Suffolk Coast & Heaths AONB Partnership (IP20025669) response to Examination Authority Questions TWO

LI.2.7	ESC, SCC, Natural England, The AONB Partnership, Stop Sizewell C, TASC	SSSI Crossing – Design Amendment Please review the amended SSSI crossing design [REP5-010] and provide comment.	<p>The AONB Partnership consider that the information provided in REP5-010 to be insufficient to assess the impact on the nationally designated AONB. It considers a Landscape and Visual Impact Assessment is required to fully understand the impacts on defined features such as landscape quality, scenic quality and tranquillity. Natural heritage features are a defined quality of the AONB and the loss of part of an irreplaceable Site of Special Scientific Interest does not support the purpose of designation or contribute to wildlife recovery.</p>

DRAWING NO:
SZC-SZ0100-XX-000-DRW-100205

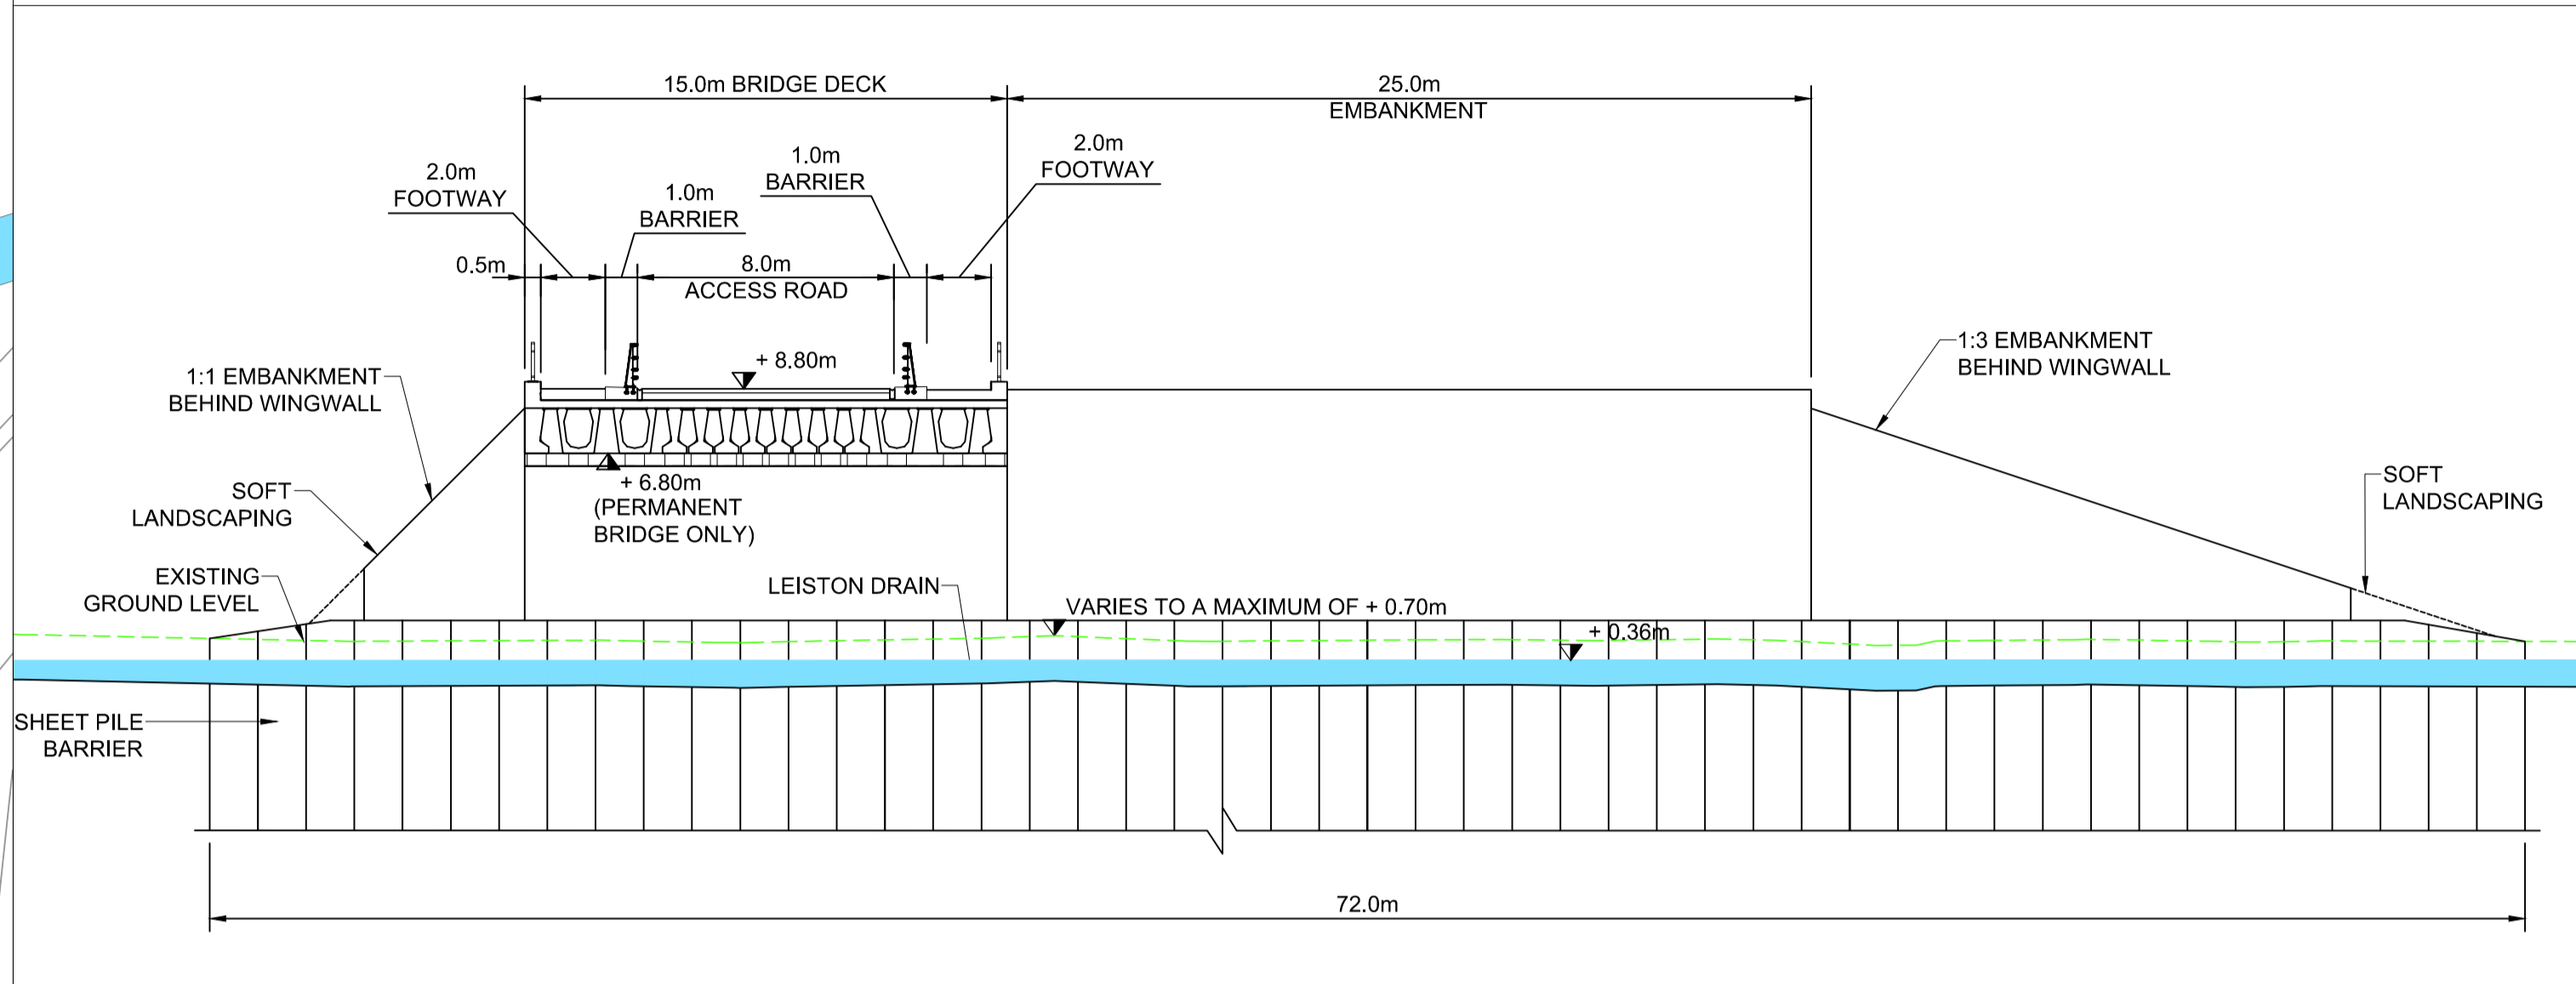
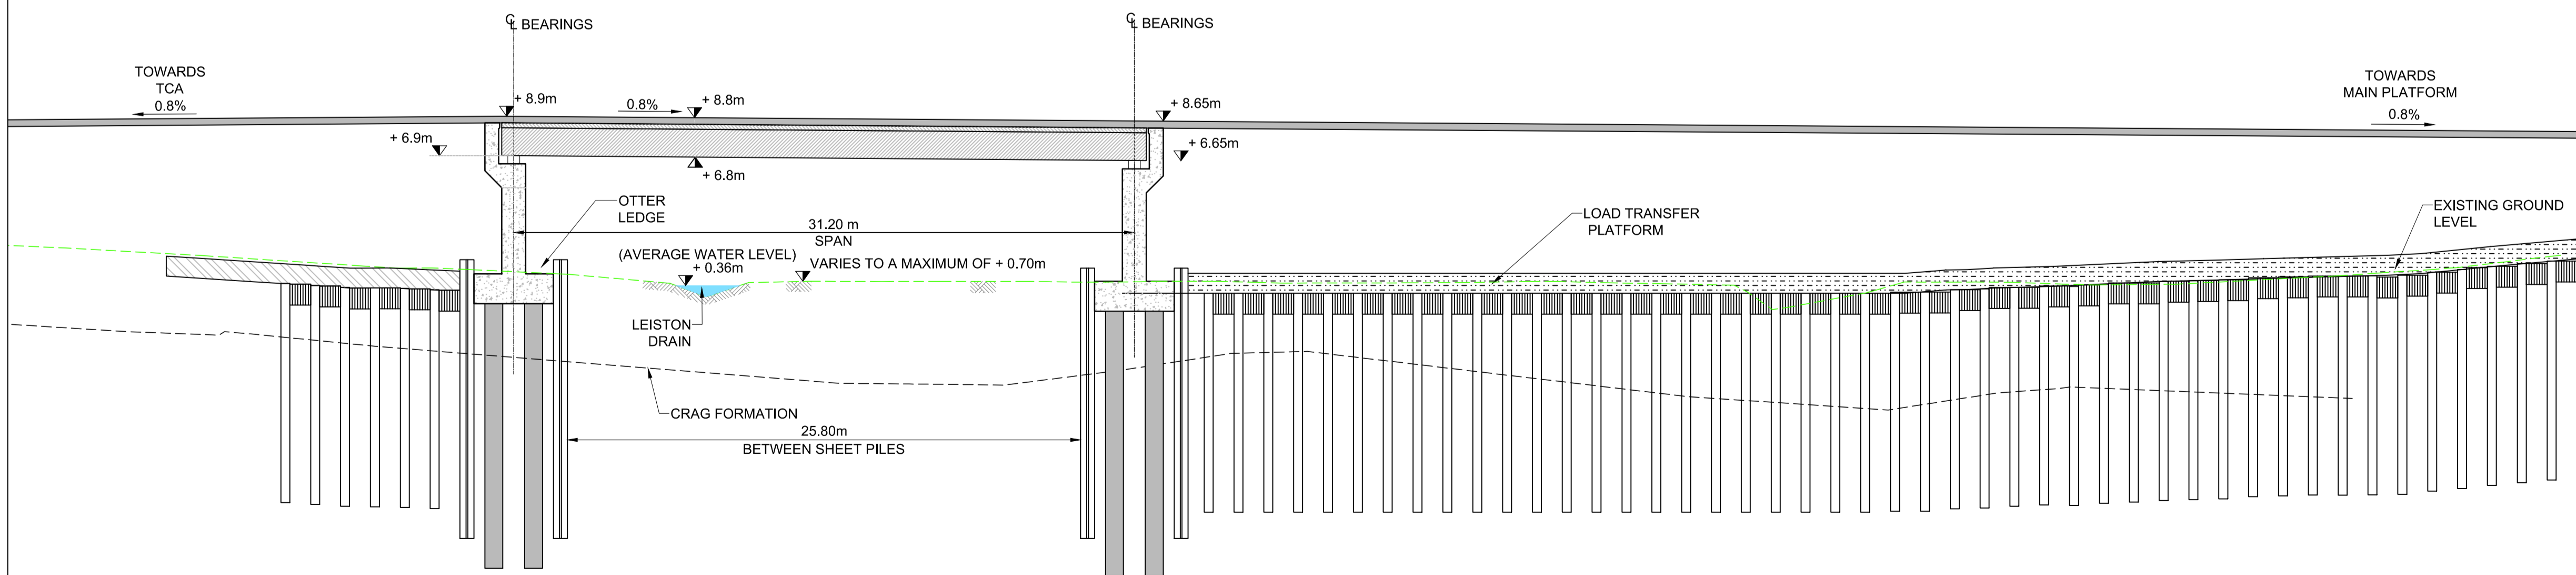
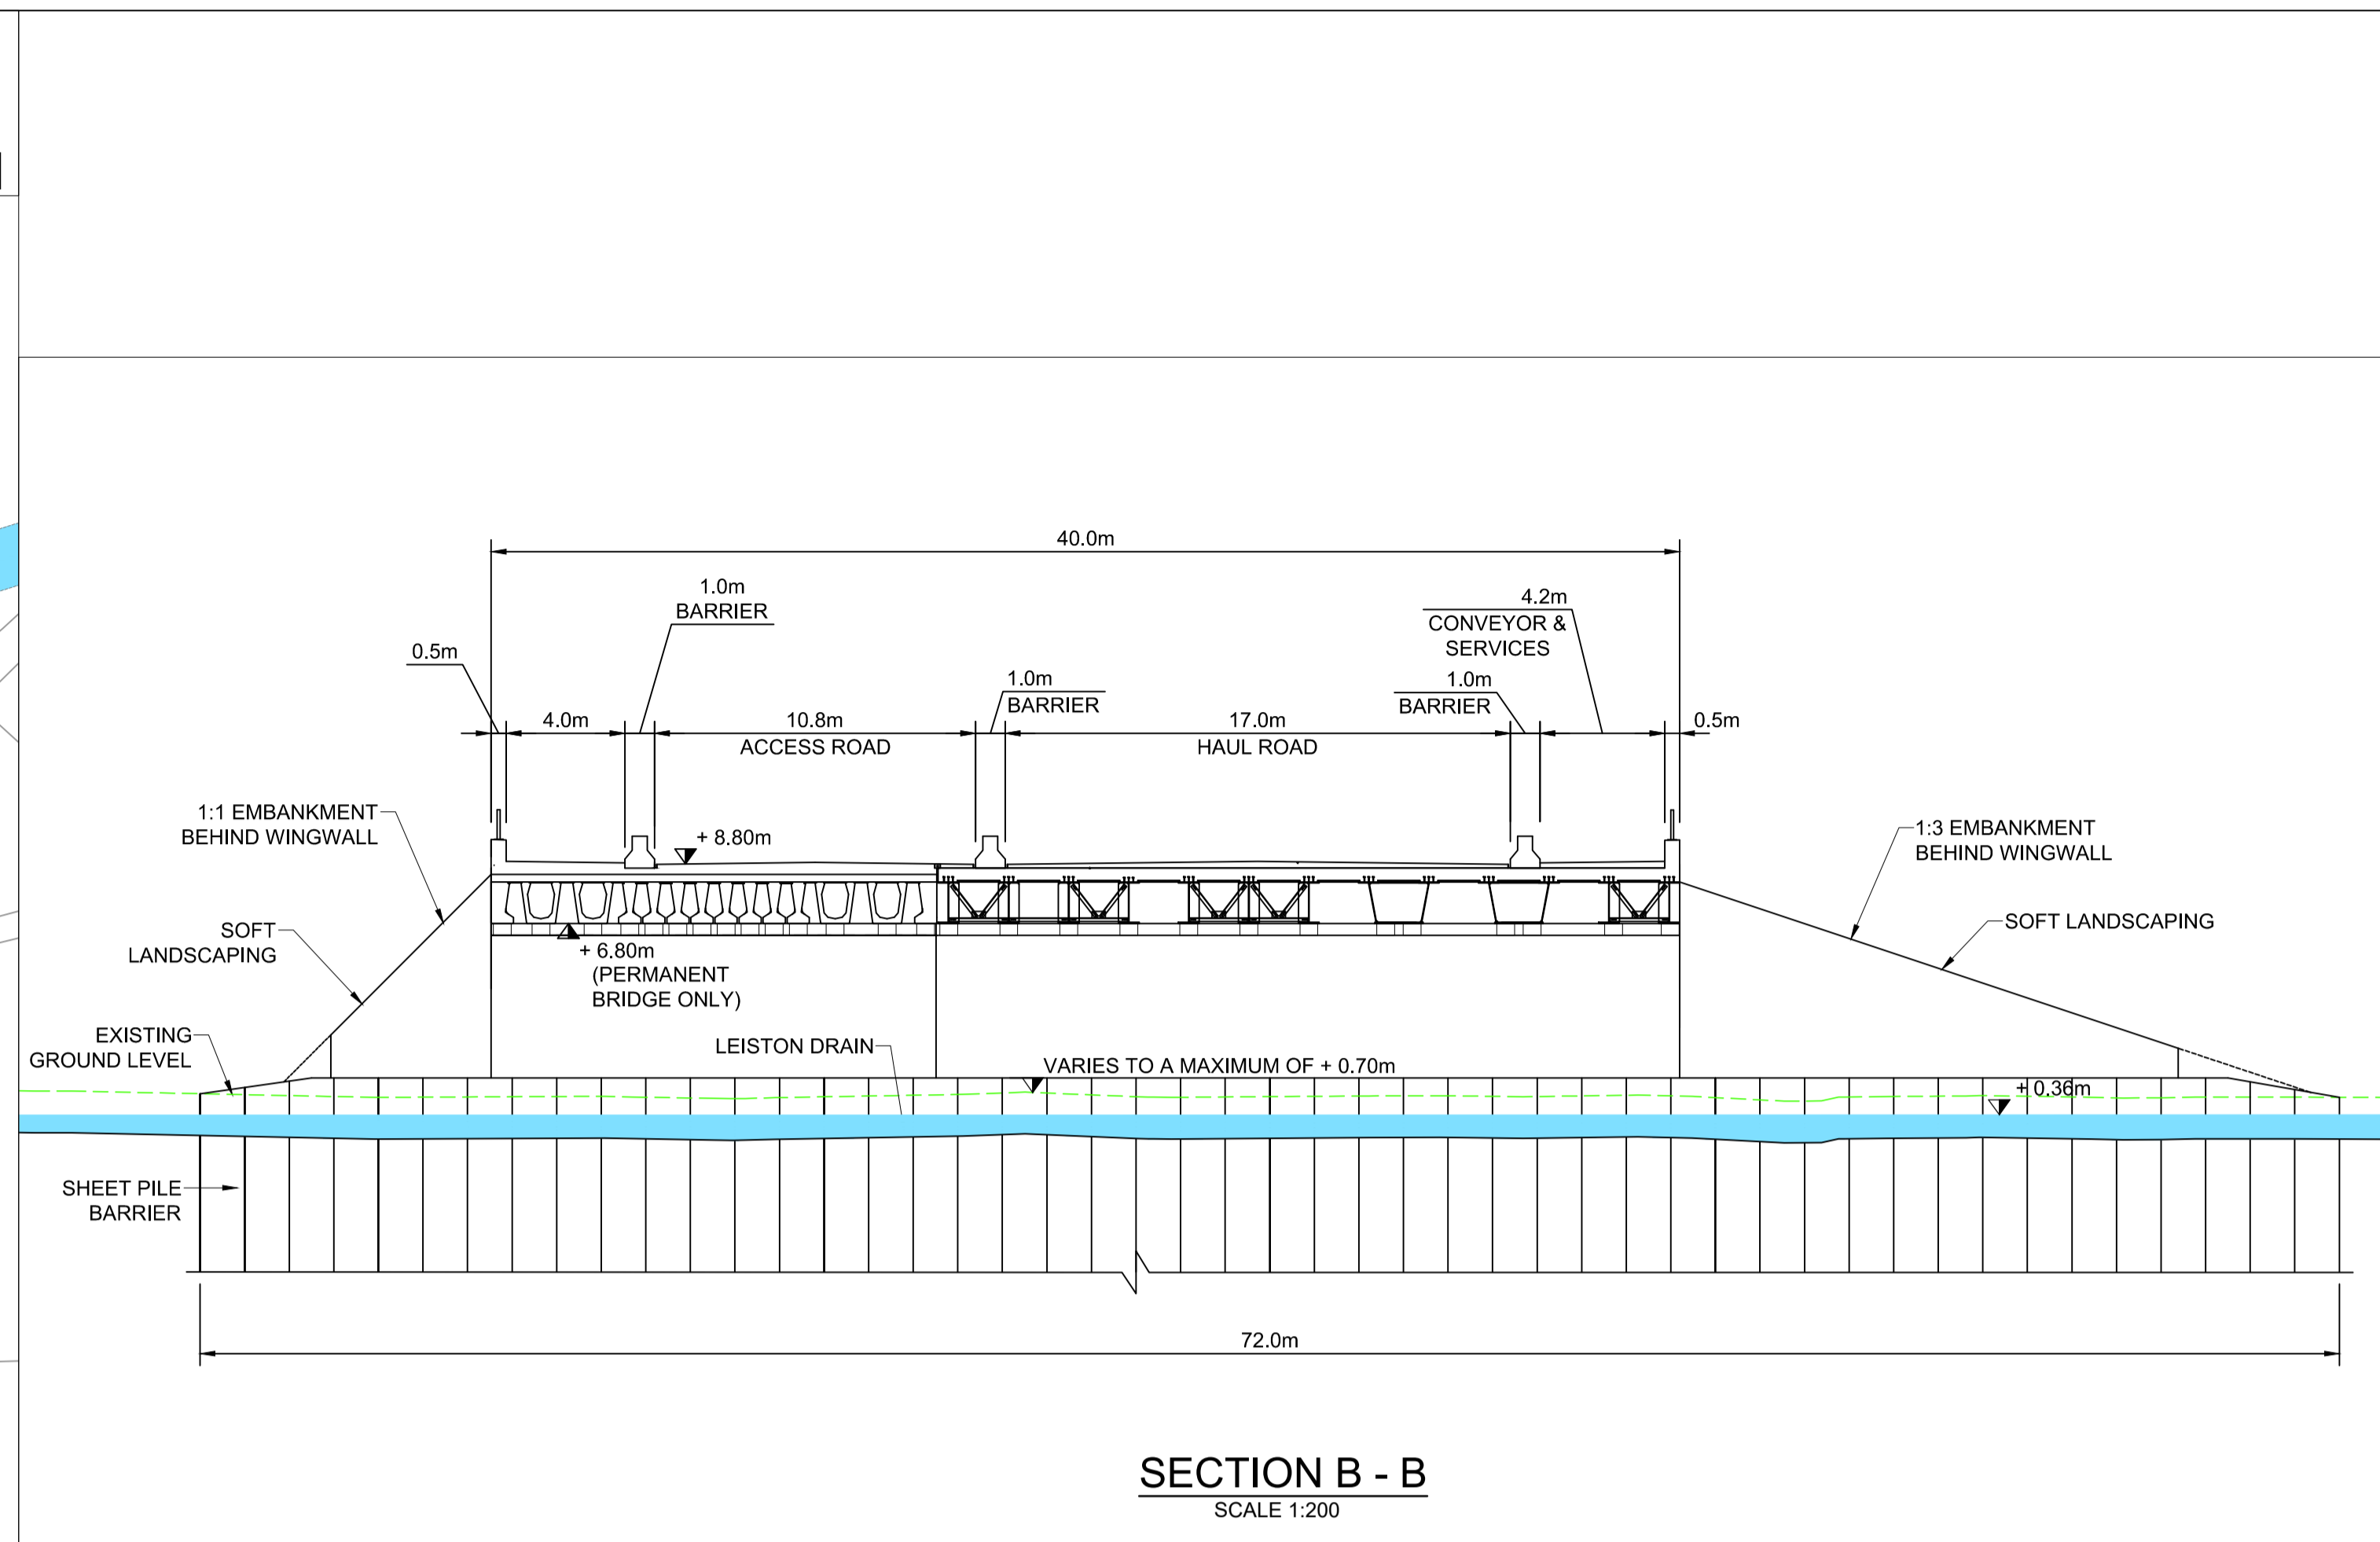
<p>Reviewing the limited detail in REP5-010 <i>The Sizewell C Project 2.5 Main Development Site. Permanent and Temporary Beach Landing Facility and SSSI Crossing Plans</i>. The AONB Partnership make the following comments:</p> <ul style="list-style-type: none"> • Detail on the use of colour should be included in the plans that should draw on the AONB guidance on the selection and use of colour in development. • The embankments as shown in the plans do not reflect the natural AONB topography in this part of the nationally designated landscape and as such do not contribute to its statutory purpose. • The introduction of 3.5m 'railings' above the road surface introduce a significant increase in height of the man made structures into the AONB and do not contribute to the purpose of the AONB.
LI.2.9	The Applicant, ESC, Natural England, The AONB Partnership, Stop Sizewell C, TASC	<p>Alternative Outage Car Park Note</p> <p>Please review and comment on the content of the SCC submission [REP5-171].</p>	<p>The AONB Partnership note that Suffolk County Council is a member of the AONB Partnership. Consultation responses from the AONB Partnership are always caveated by the assumption that individual members of the Partnership will make their own responses reflected their full remit.</p> <p>AONB Partnership comments on Suffolk County Council comments are made in the context that Suffolk County Council is a funding partner and host of the AONB staff team. For information, AONB Partnership consultation responses for AONB are drafted by the staff team for</p>
